OXFORDSHIRE COUNTY COUNCIL'S RESPONSE TO CONSULTATION ON THE FOLLOWING DEVELOPMENT PROPOSAL

Application no: 21/00503/F-2

Proposal: Use of the site for the storage of operational vehicles, elevational alterations, associated parking, vehicle barriers, guard hut and associated infrastructure

Transport Schedule

**PROPOSED SITE PLAN**  
1:500

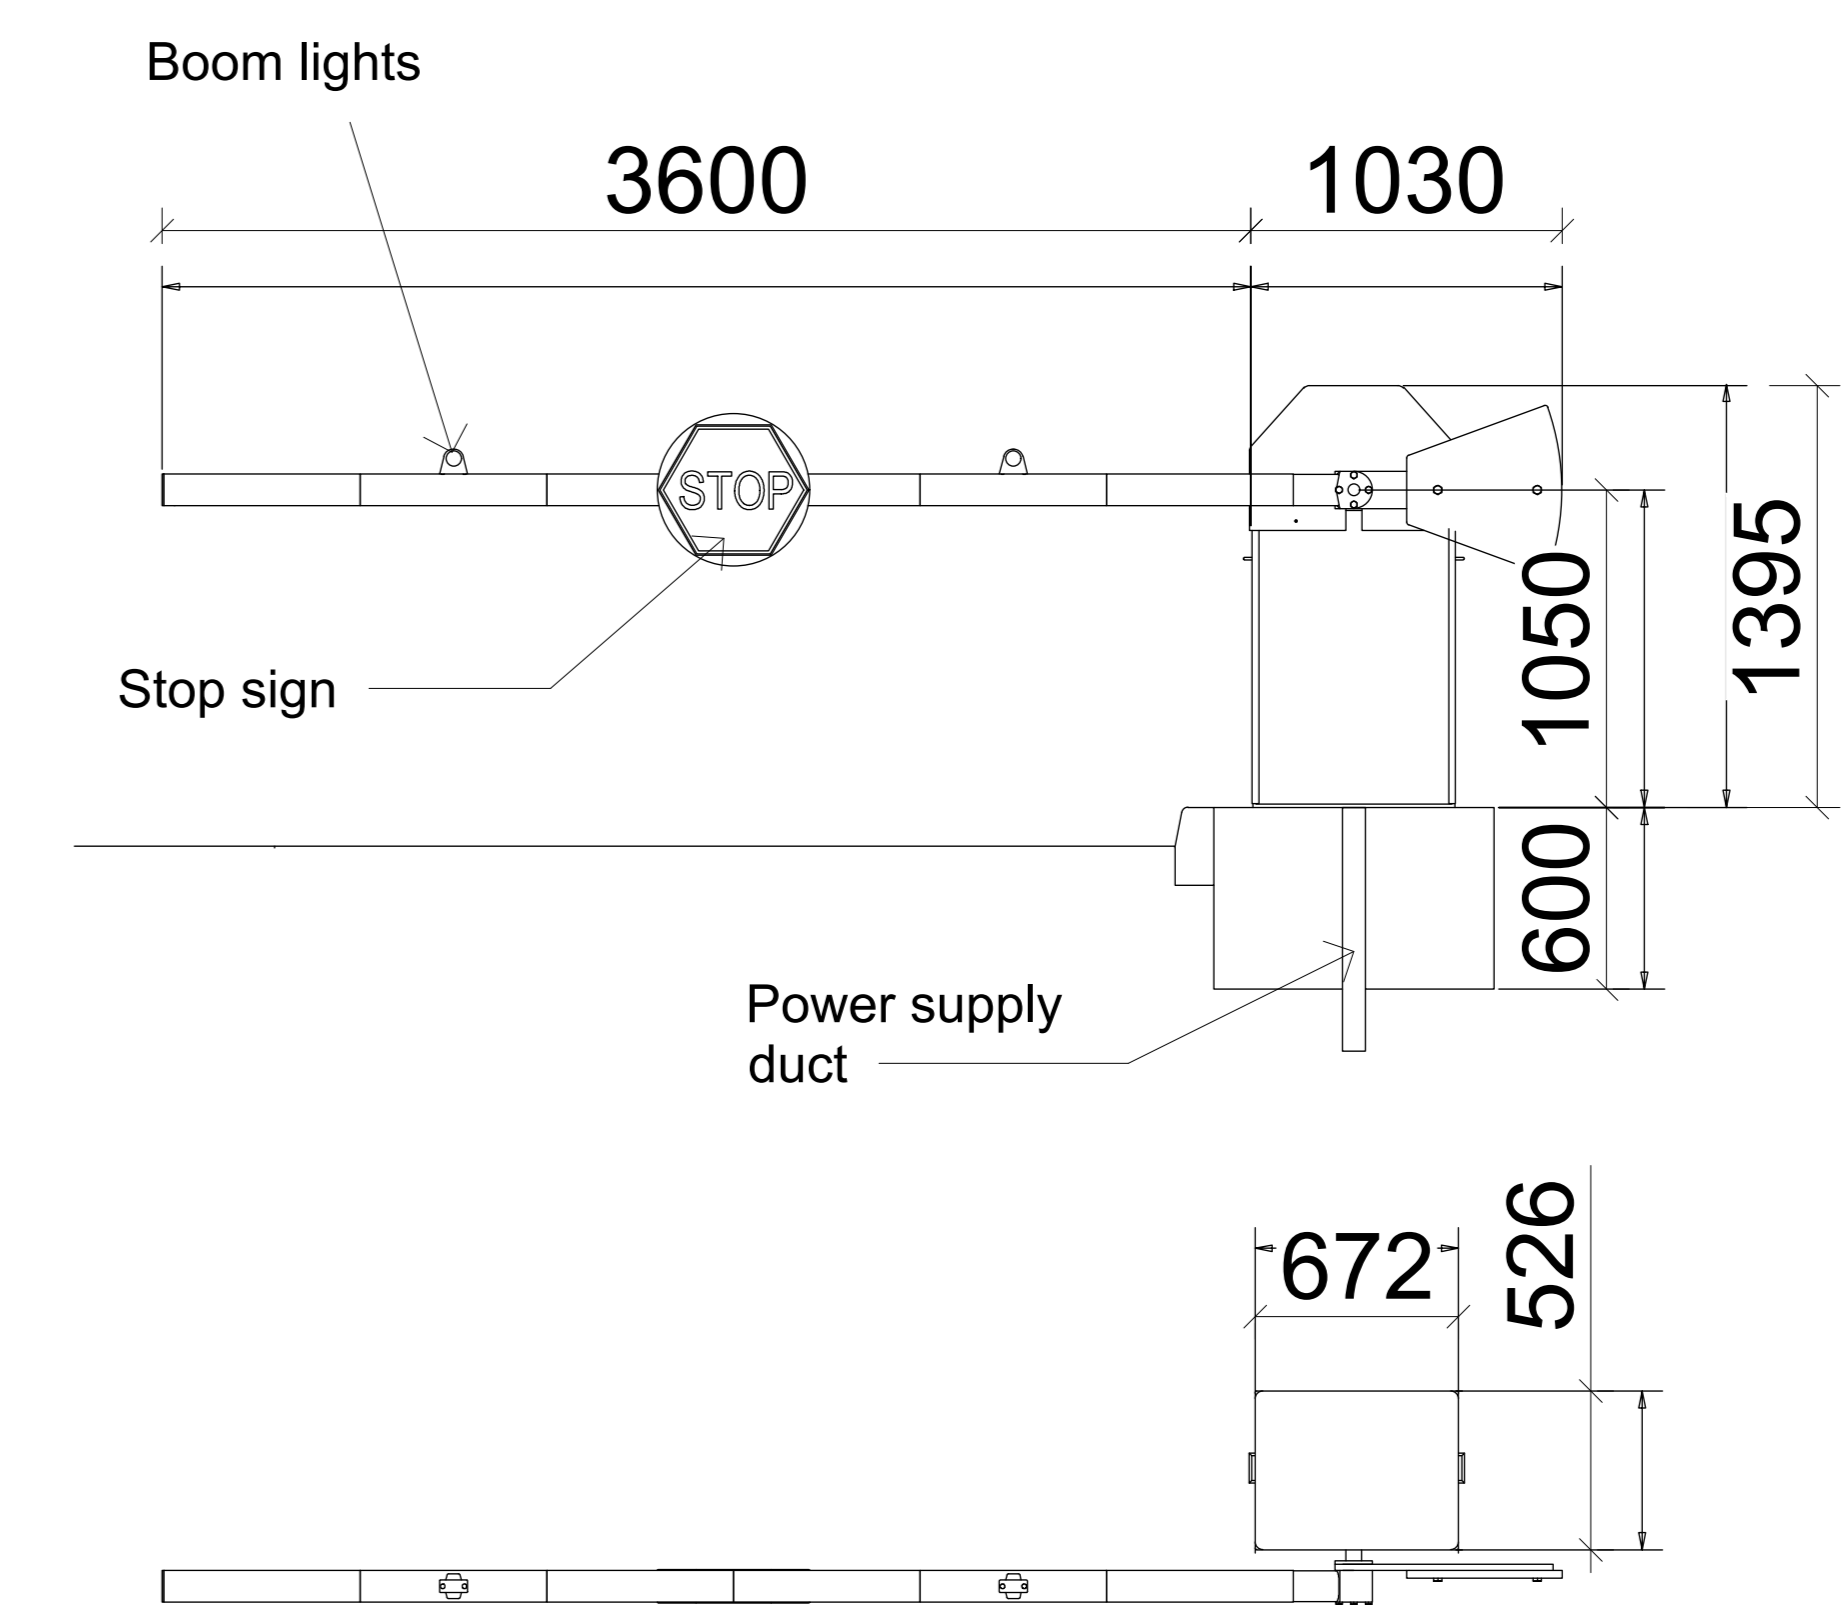
- The external lighting Lux Plot drawing no. 10336-PL-100 Rev OCC Street lighting Officers for comments, Applicant. The lighting arrangement is not be to OCC specification so required to establish if this road a private road.
There is no indication as to what category or classification the developer is trying to achieve with the lighting arrangement/levels. The lighting levels seem higher to what OCC would specify and the colour temperature is 4000k which is higher than we

would use which is 3000k. The light the fittings are similar to what we would approve.
